Letter of Intent

Request for Administrative Relief for Guest House

Kevin and Michelle Colvin
11660 Green Acres Lane
Black Forest, CO 80908

1 SITE PLAN  
SCALE: 1" = 40'

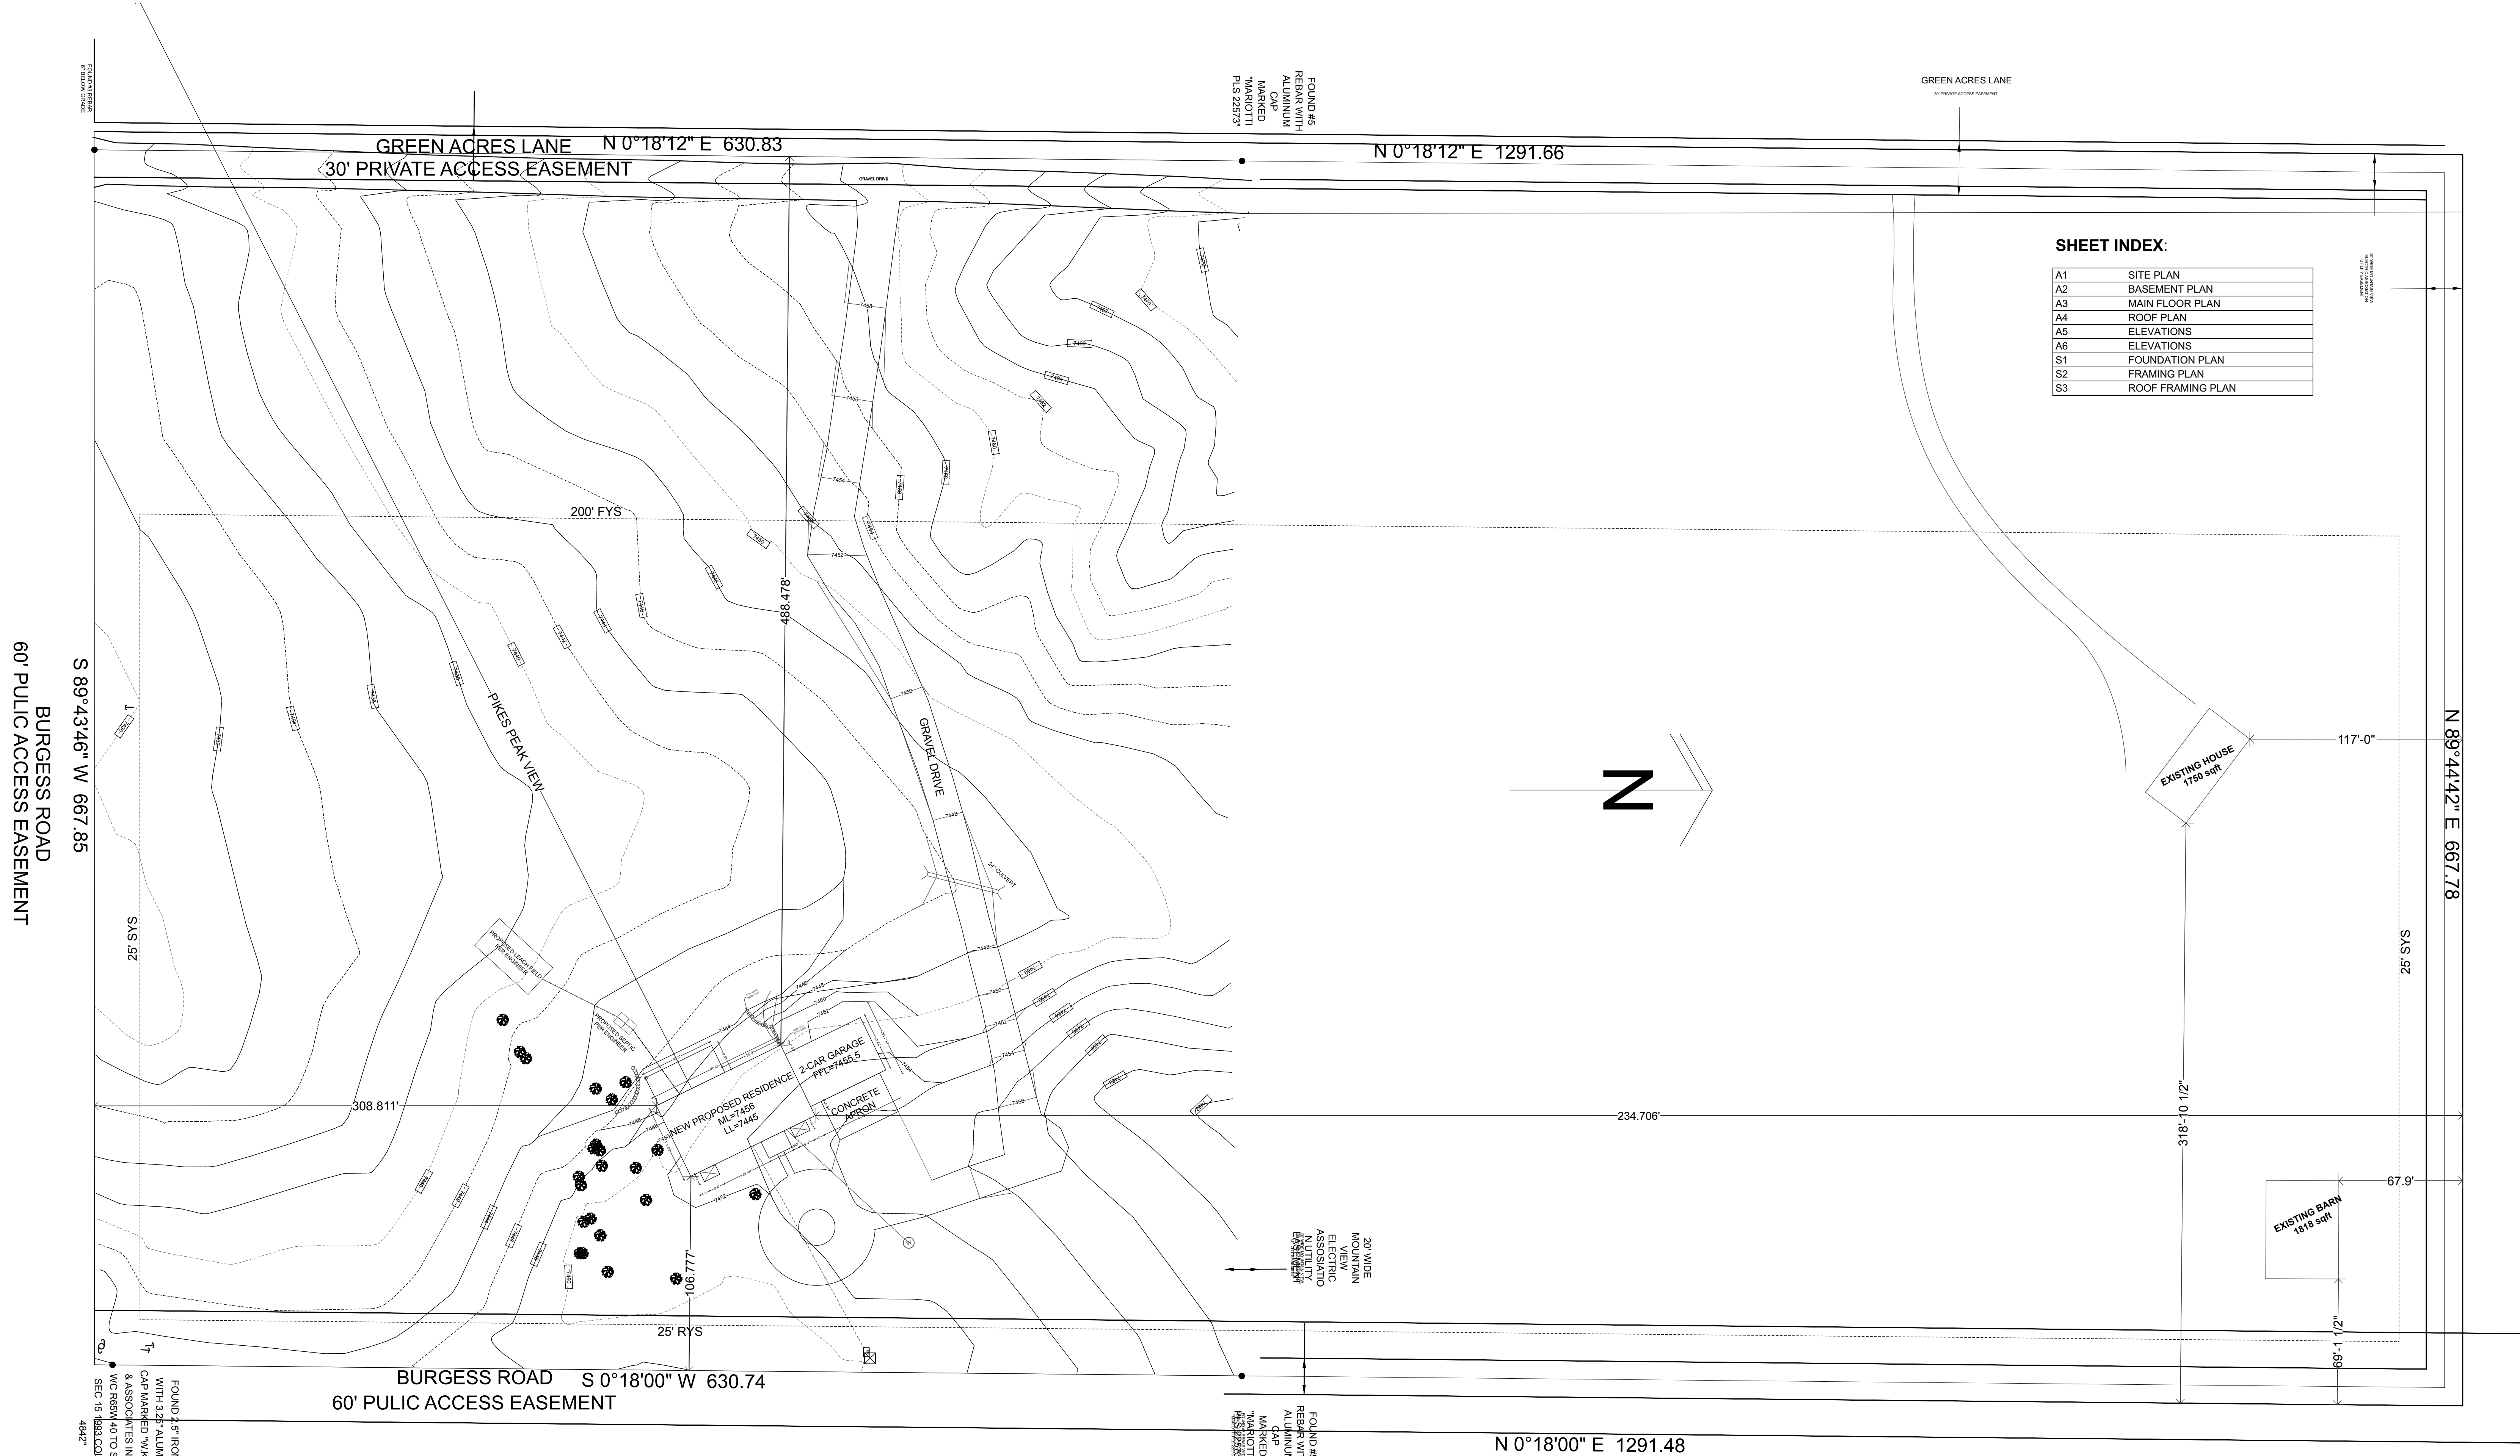
Verify this number by
providing floor plans
drawn to scale of the
entire floor area. This
does not match your
site plan.
